**The Children's Hospital at Westmead - Multi-storey Carpark (SSD-10434896)
Corner of Hawkesbury Road and Hainsworth Street, Westmead
Response to Submissions Report**

ATTACHMENT 1 – KEY ISSUES

| CHW-AR-DG-MCP-DA051 |            |            |          |

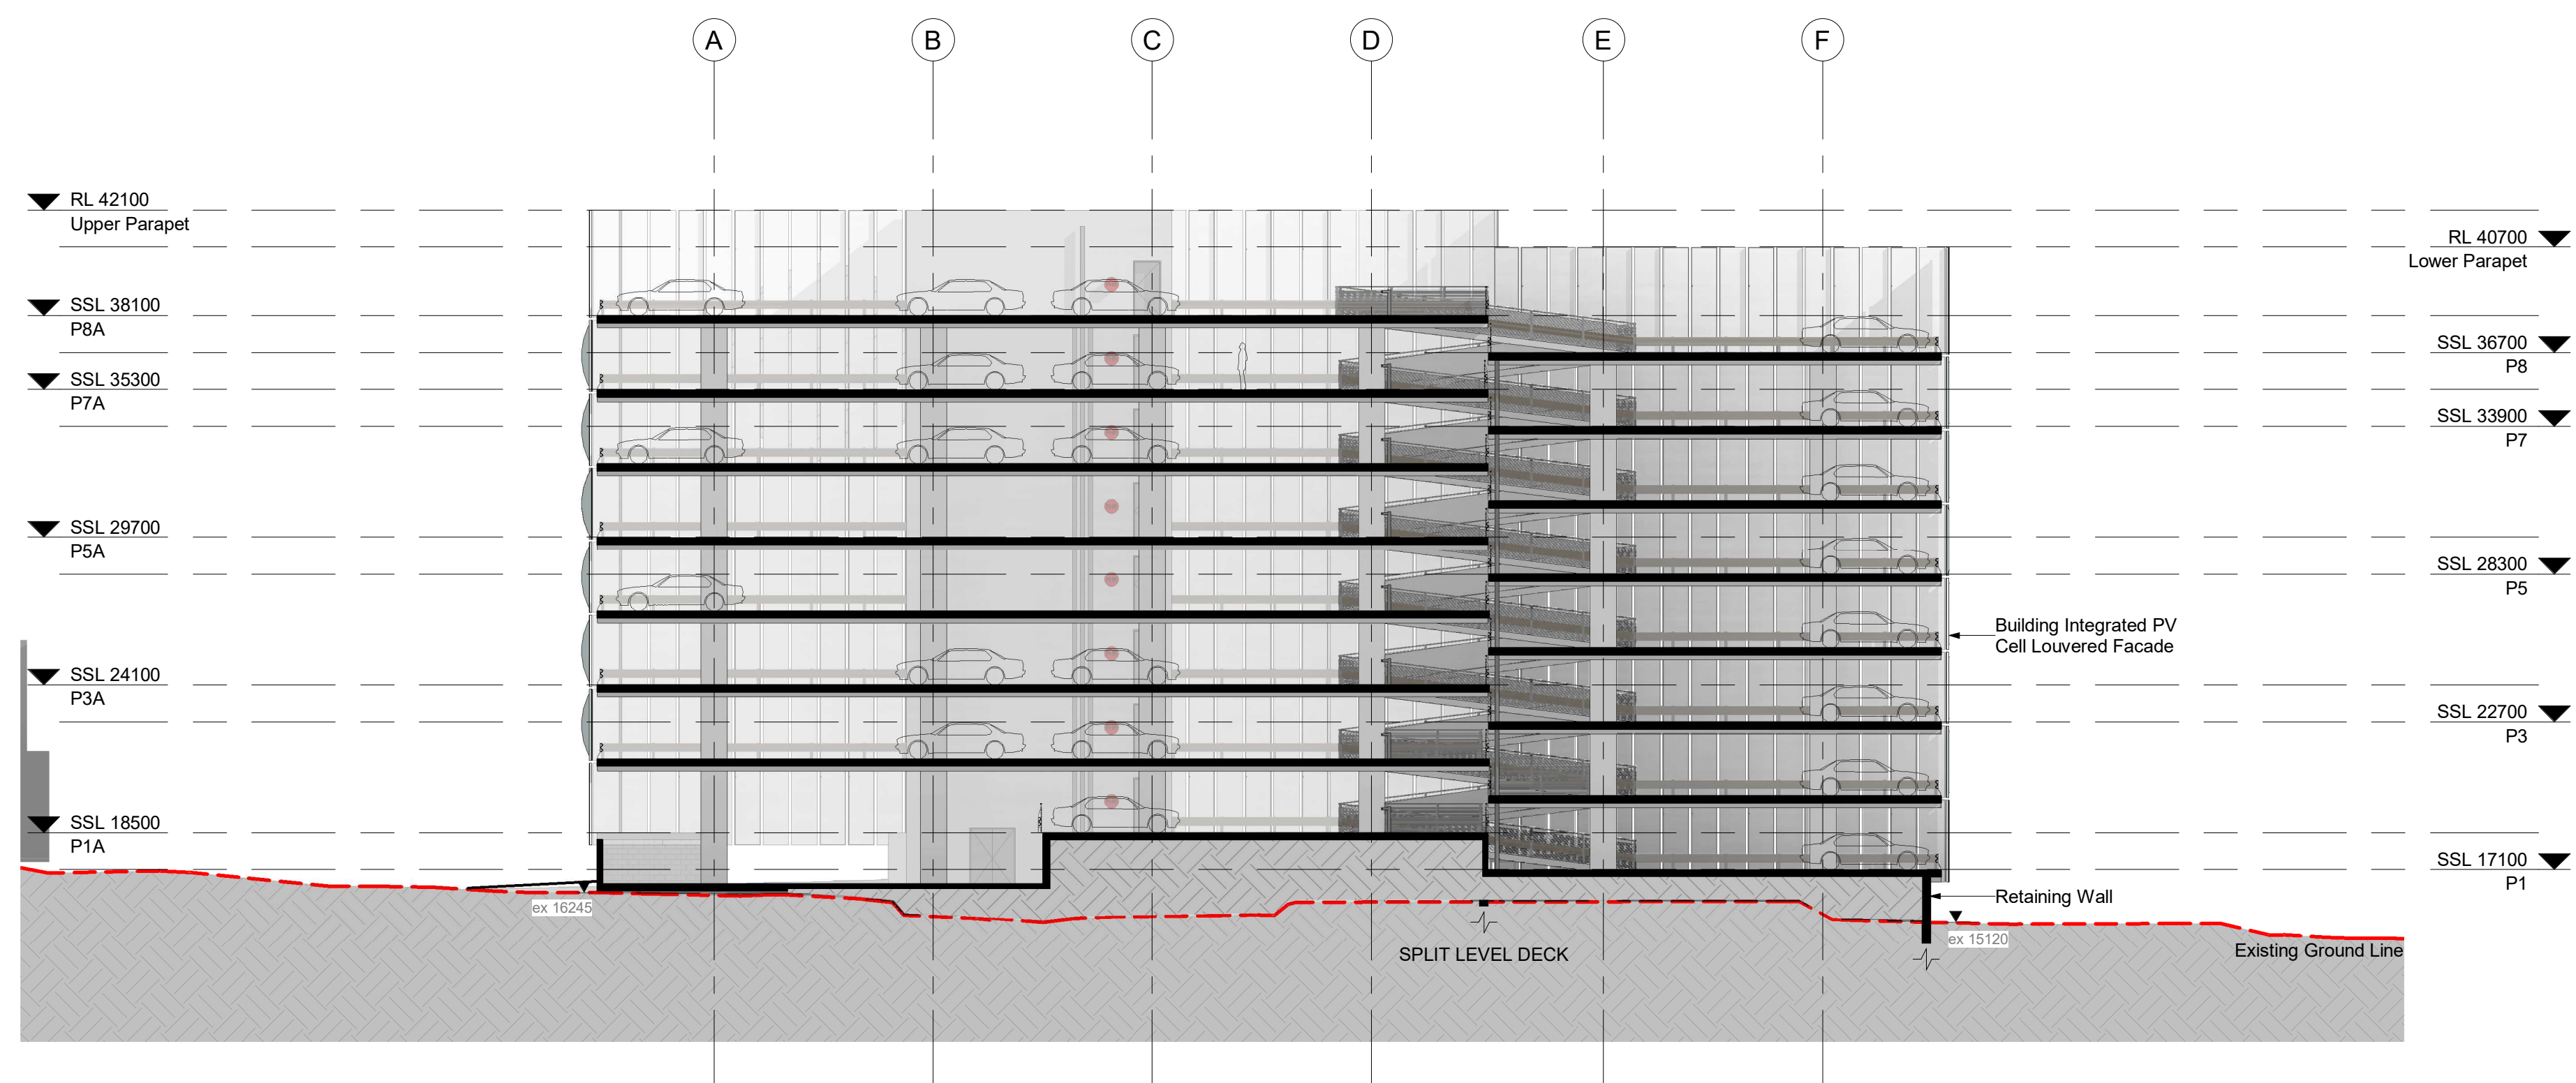
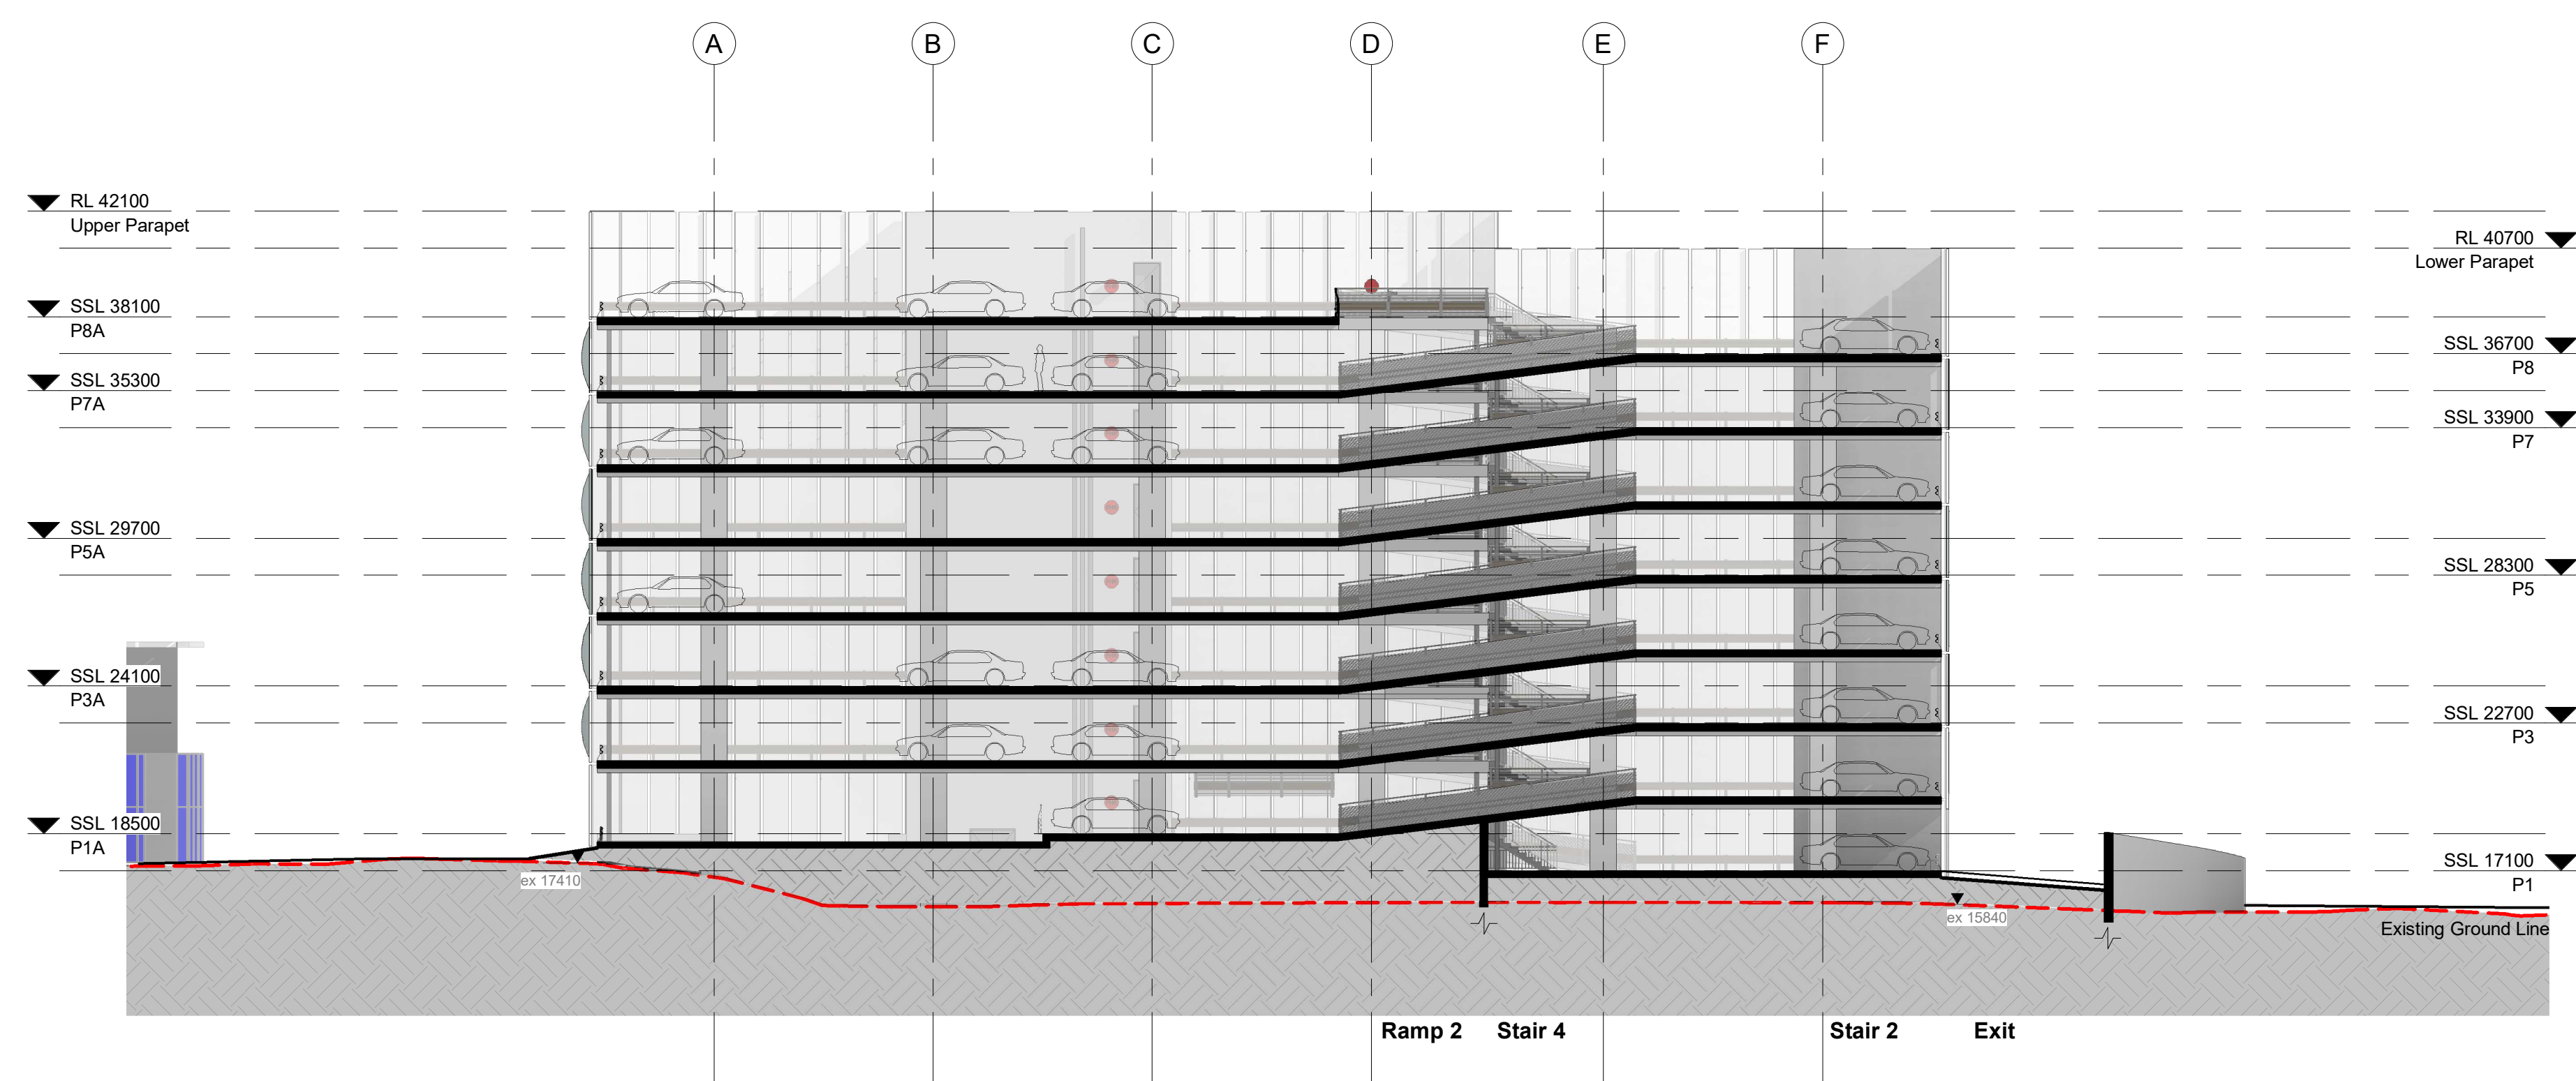
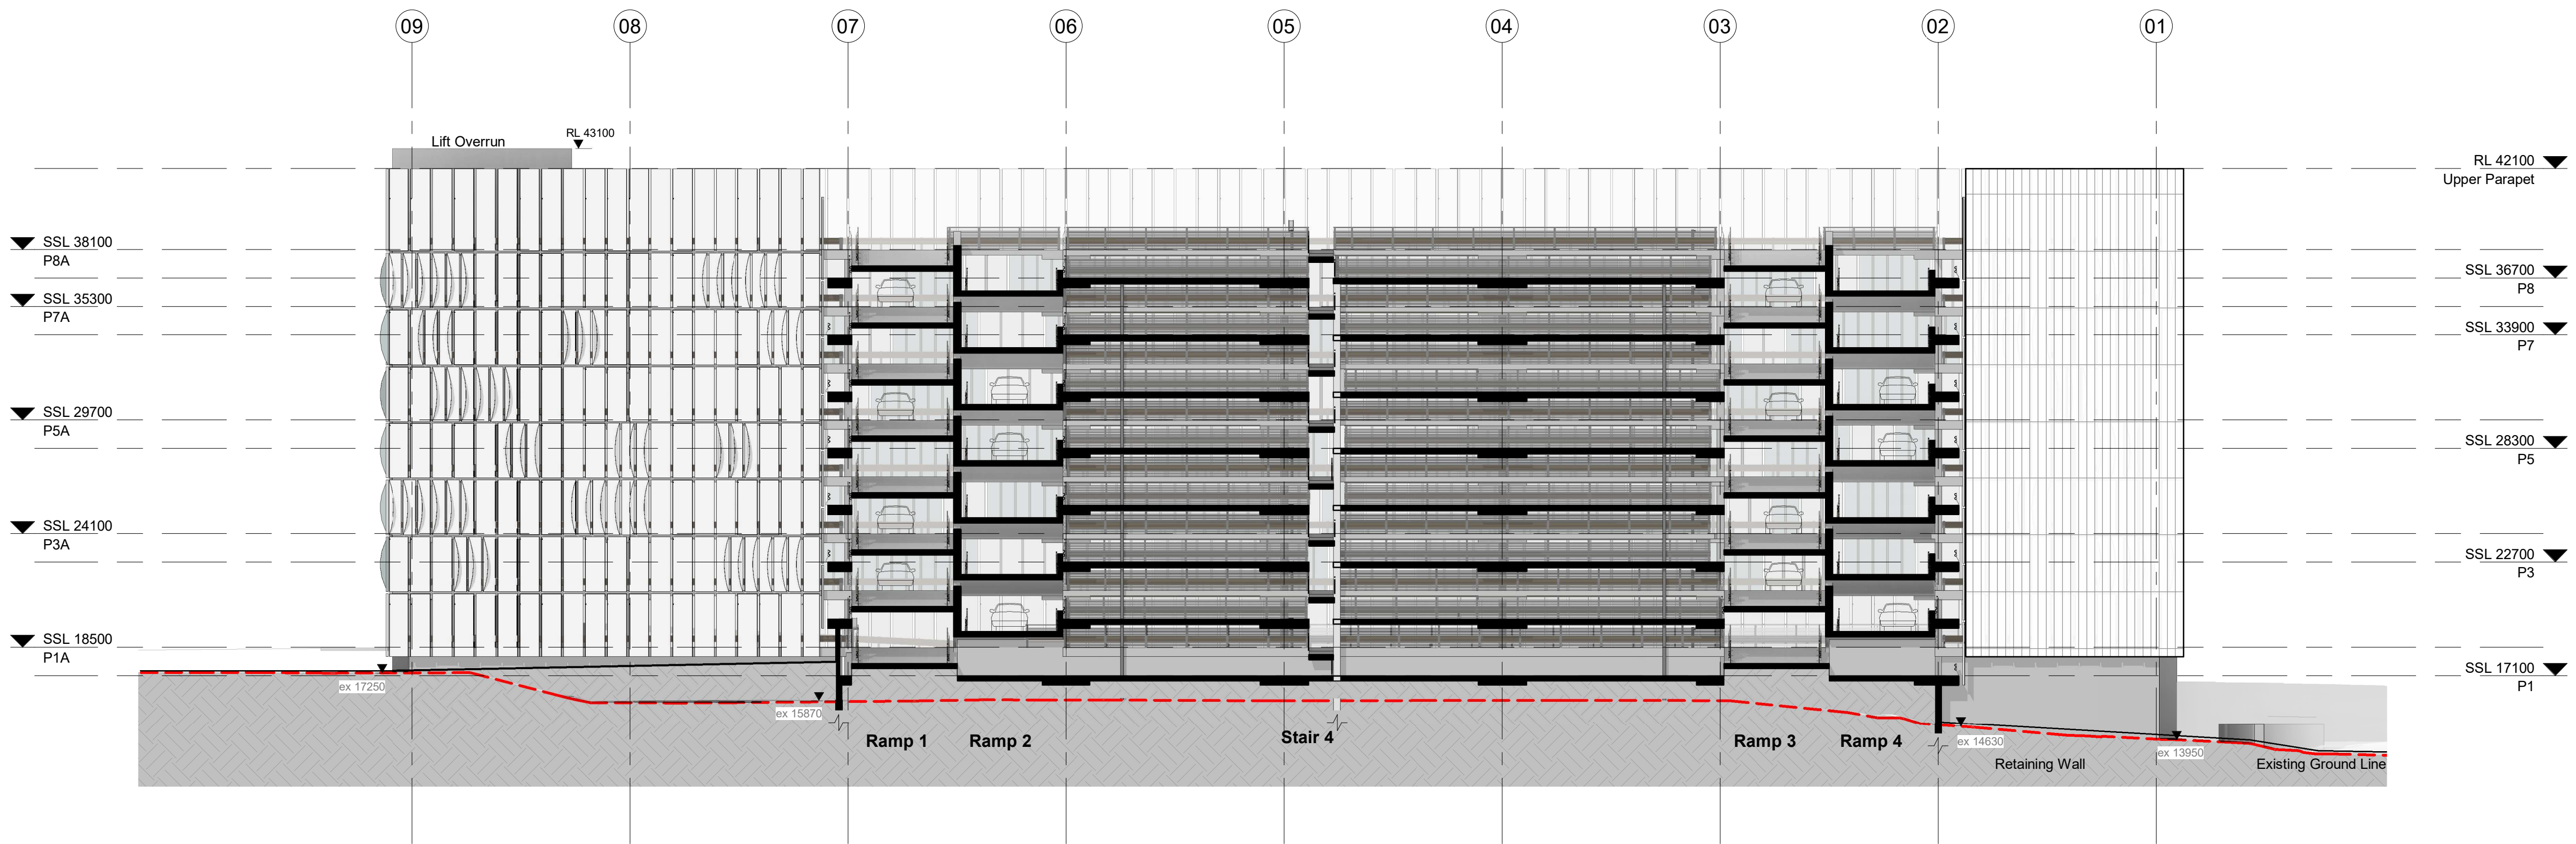
5. Updated architectural / landscape plans are to be submitted providing:
 - a) further detail of the proposed solar panel façade and/or roof canopy design in accordance with the ESD report.
 - b) confirmation of compliance with relevant Australian Standards for off-street parking facilities (parking space dimensions).
 - c) identify the location of motorcycle parking spaces.
 - d) the inclusion of public amenities, preferably in the vicinity of disabled parking spaces.
 - e) the integration of a retail offering adjacent to the kidsway and playground area.
 - f) the detailed design of the new universal access playground, including an investigation into potentially relocating these facilities to the vacant turfed area opposite the Remembrance Garden to enable improved solar access.
